Our Ref RG/SPRUSTINGTON6.1
Your Ref A/23/15/OUT

Mixed-Use Development on Land south of A259 New Road and East of Brook Lane, Angmering, West Sussex

We write, on behalf of our client Store Property Investments Ltd, to comment on the proposed development at the above site. Specifically, our comments below are in relation to the West Sussex County Council (WSCC) Consultation Response dated 14th August 2015.

Title
HIGHWAY ACCESS PLAN

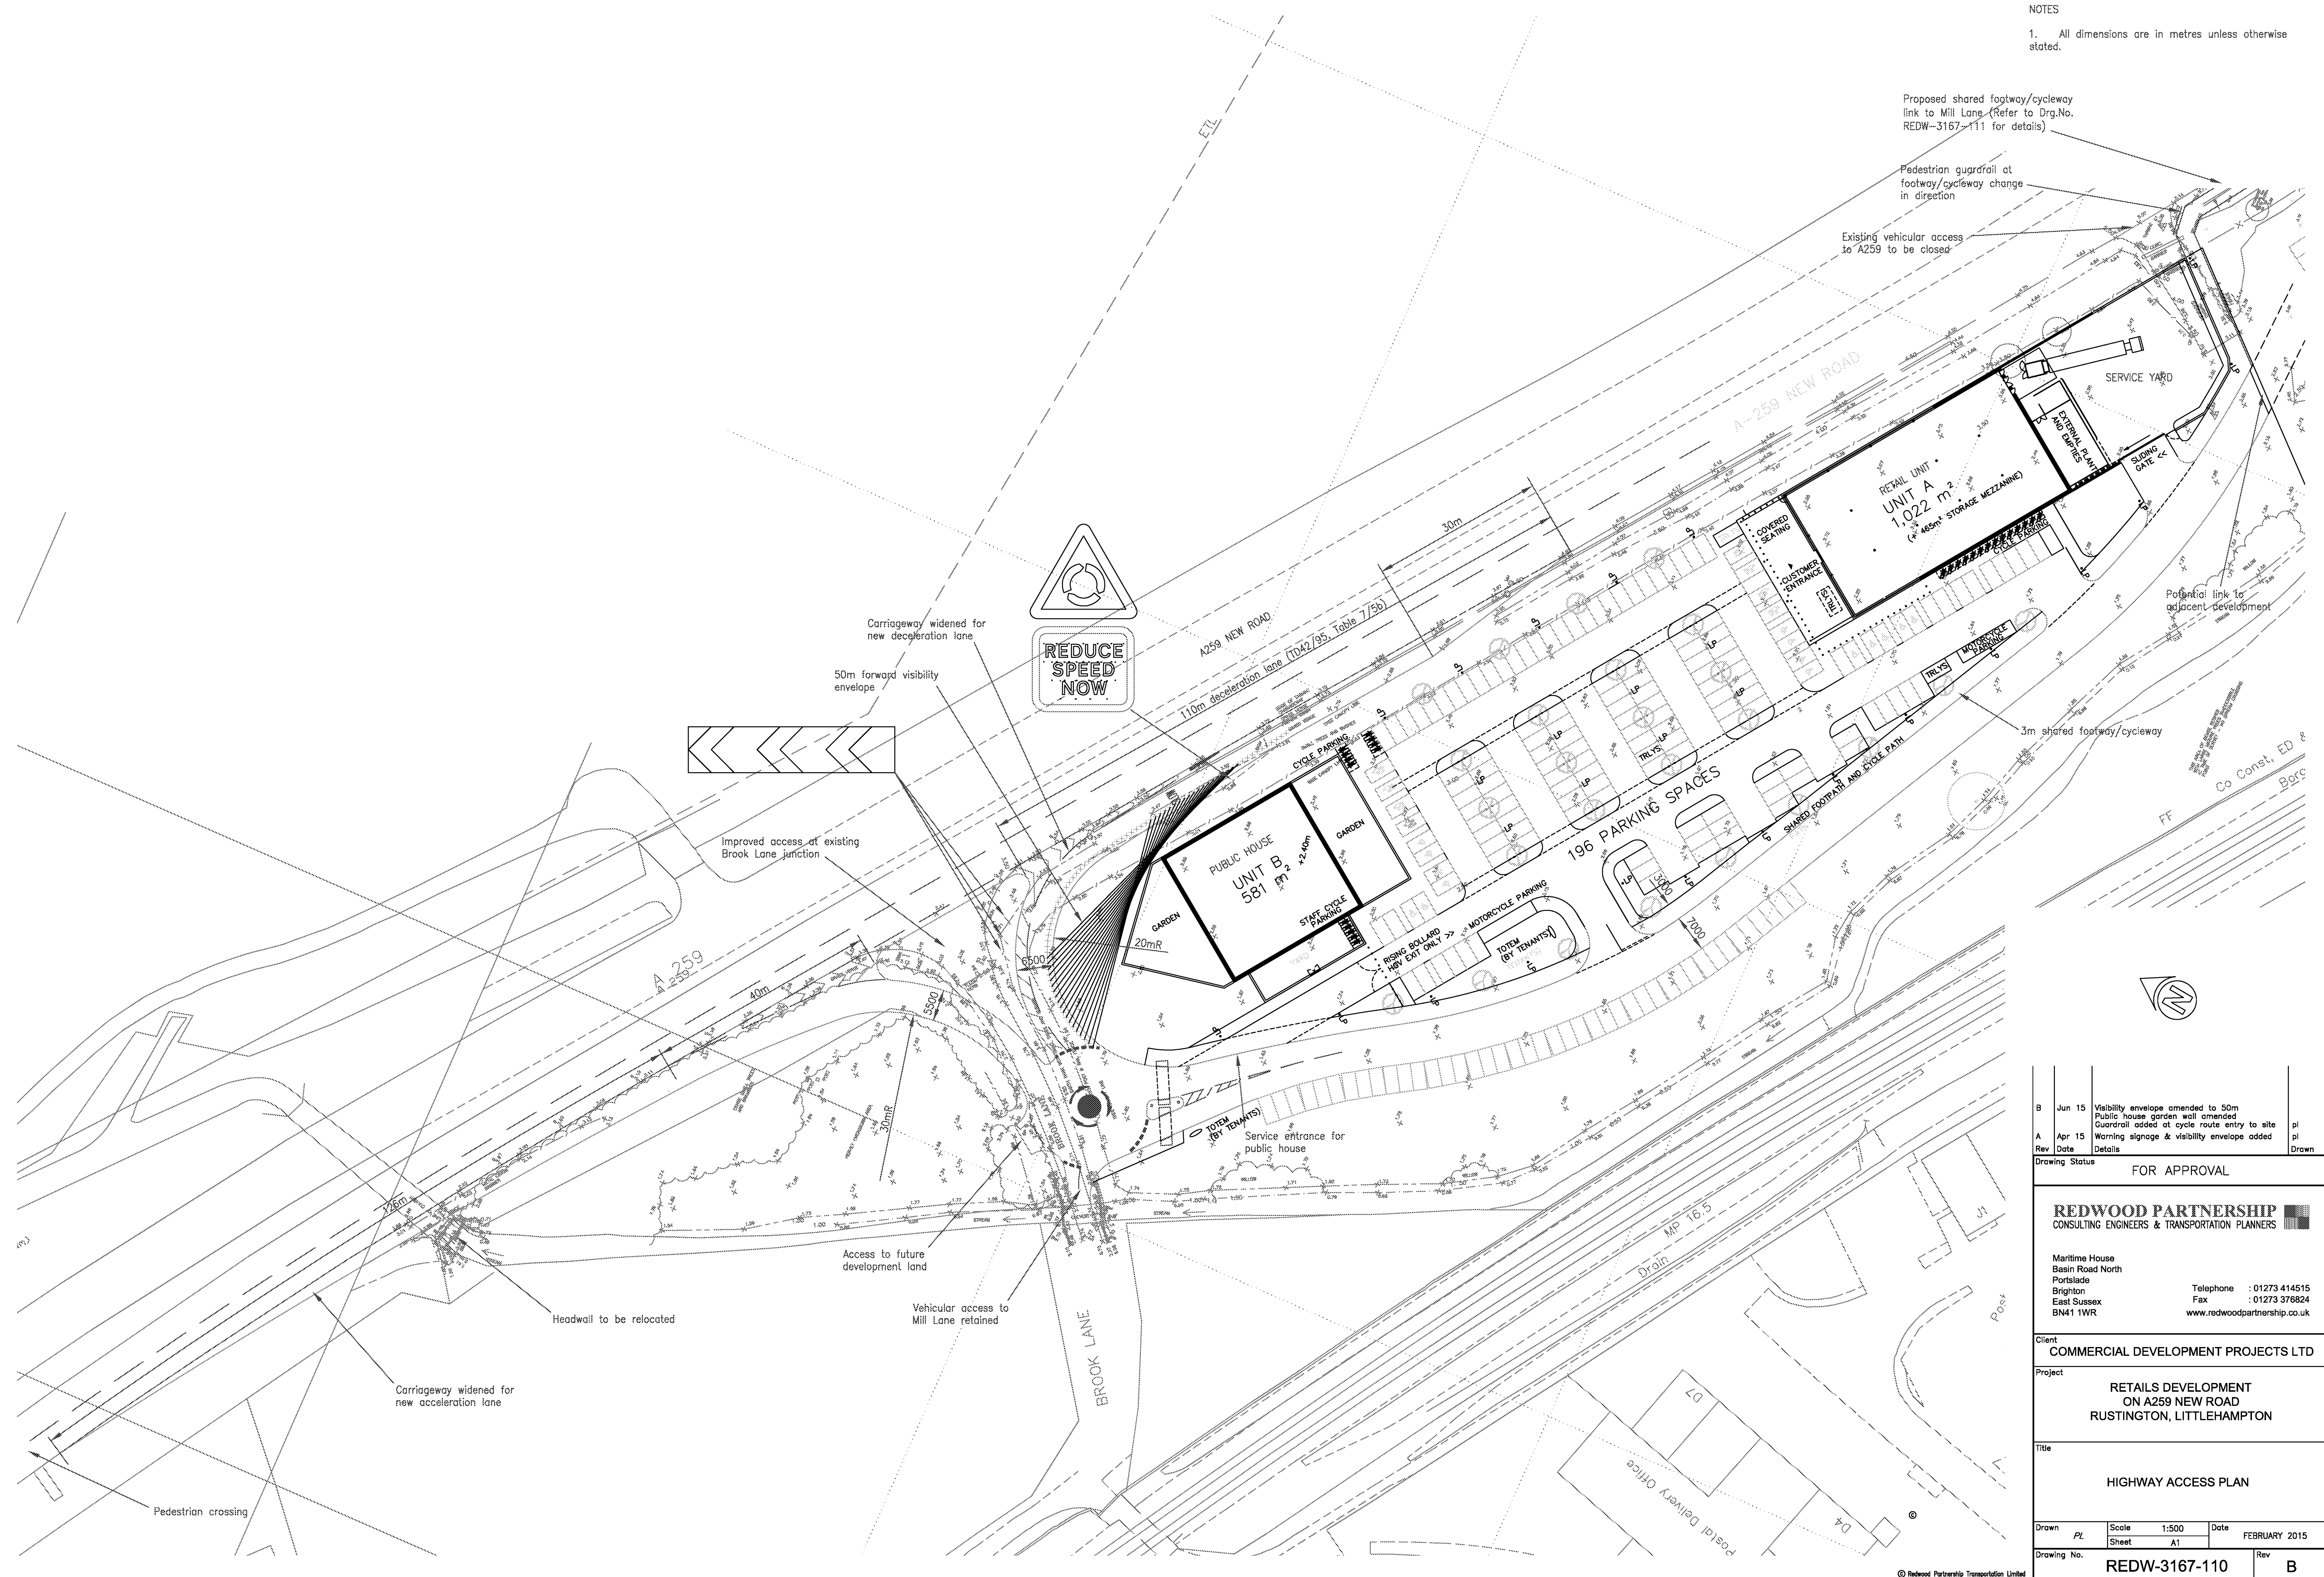
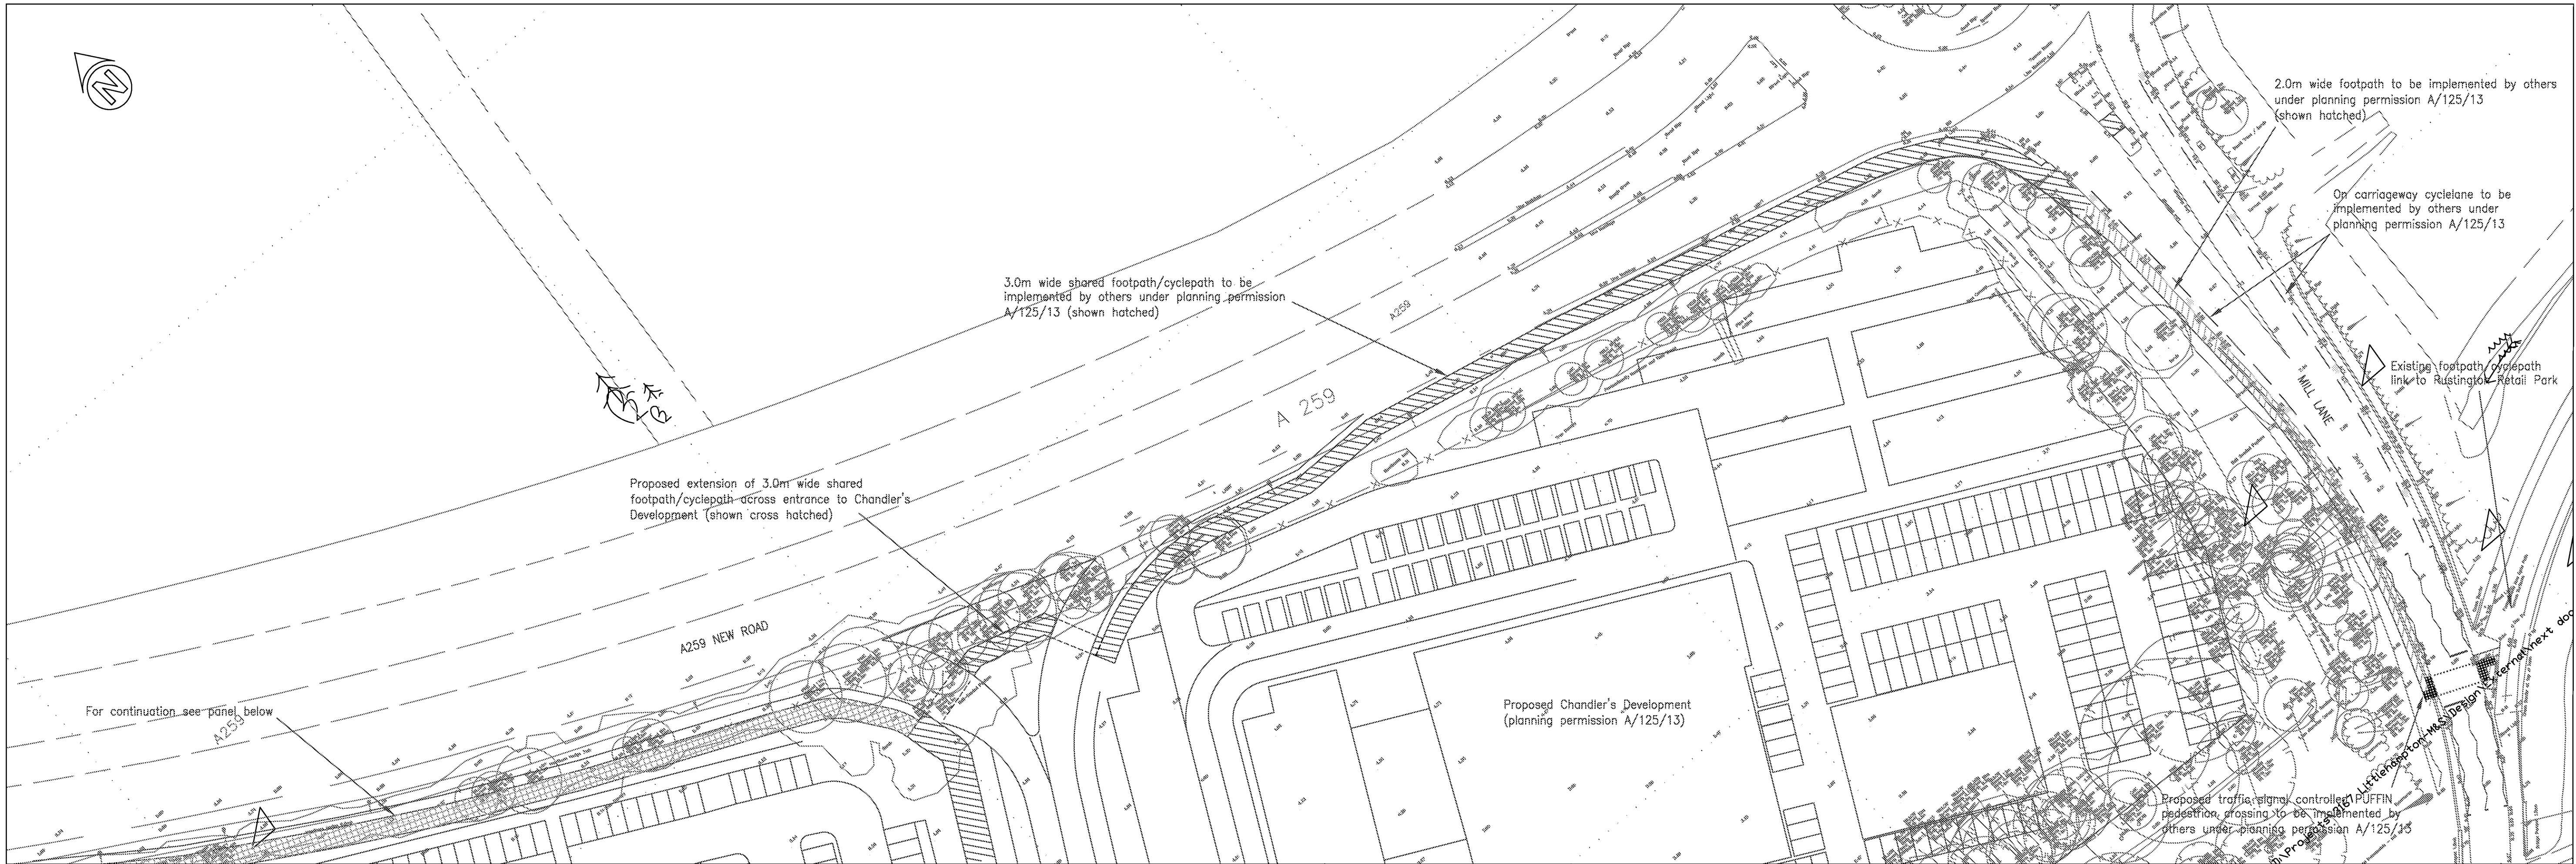
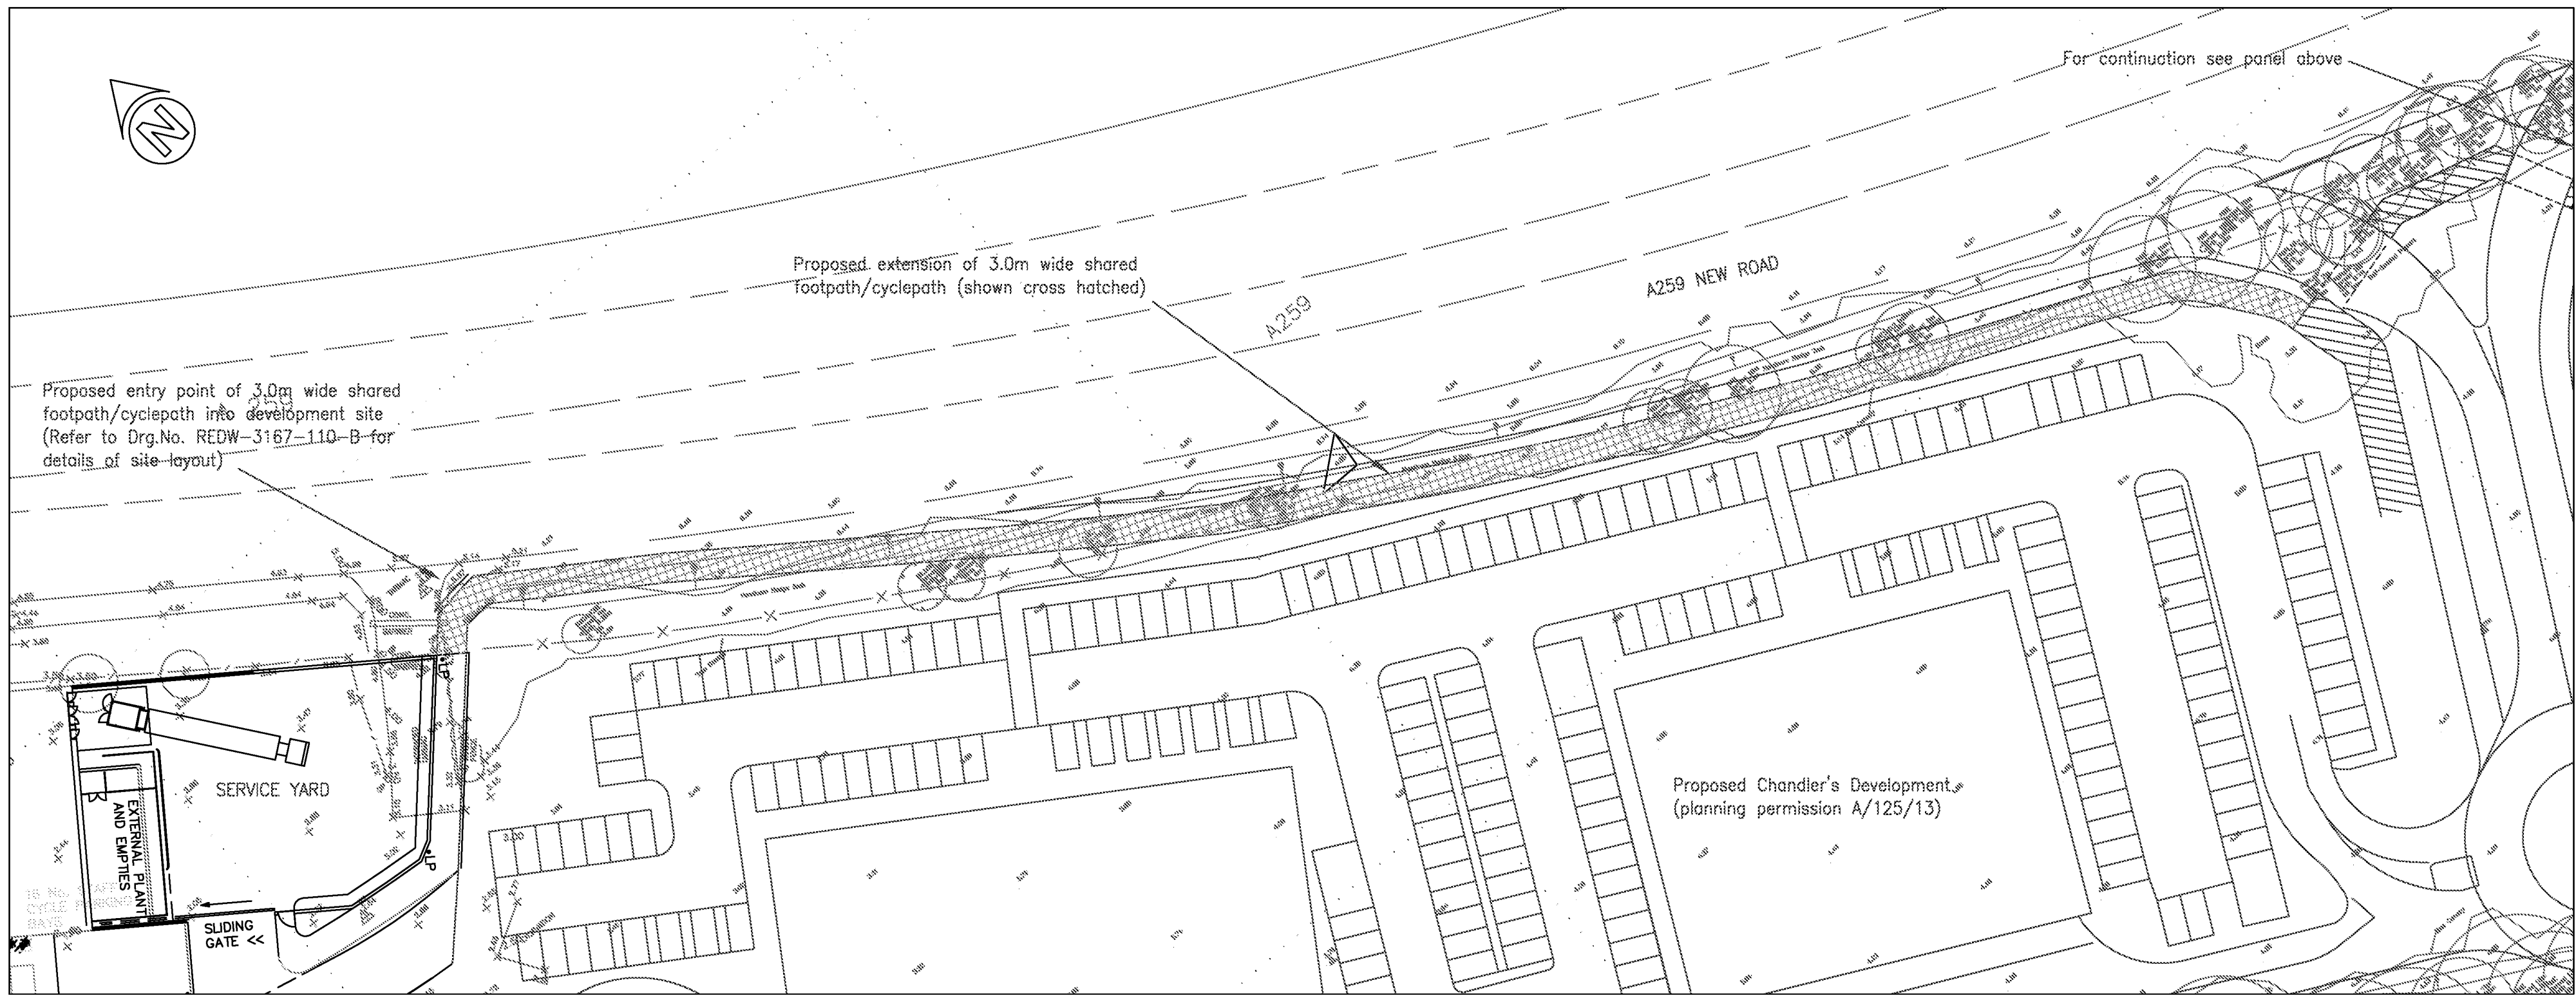
- It is stated in the response from WSCC that it is their view that the Brook Lane arm of the mini-roundabout could be better served as a crossover resulting in a three arm roundabout. The below sketch was included along with this comment.

Whilst it is appreciated that the sketch is for diagrammatic purposes only, we have concerns as to how this would operate and the potential safety implications, especially when taking into consideration the potential impact of future development using the western arm of the roundabout. Specifically, concerns are regarding the visibility to and from the Brook Lane crossover and the unknown intensification of use of the roundabout when considering the potential for future development on the site to the west. It is therefore considered that if WSCC consider that the developer's proposal of a four arm roundabout is not suitable then a full redesign is required taking all existing and potential future users into consideration.

- It is also stated in the WSCC response that the proposed layout would encourage 'trespass' on Brook Lane between the roundabout and the railway crossing and that the developer should therefore secure a right of way along this route. As has been stated in previous correspondence, and contrary to the view of the developer, we wholeheartedly agree with WSCC on this point as the railway crossing and Brook Lane provides access from the large residential areas to the south and it seems entirely logical that pedestrians would use Brook Lane to access the development. This should be considered alongside Network Rail's concern regarding safety at the railway crossing as part of proposed pedestrian access improvements.
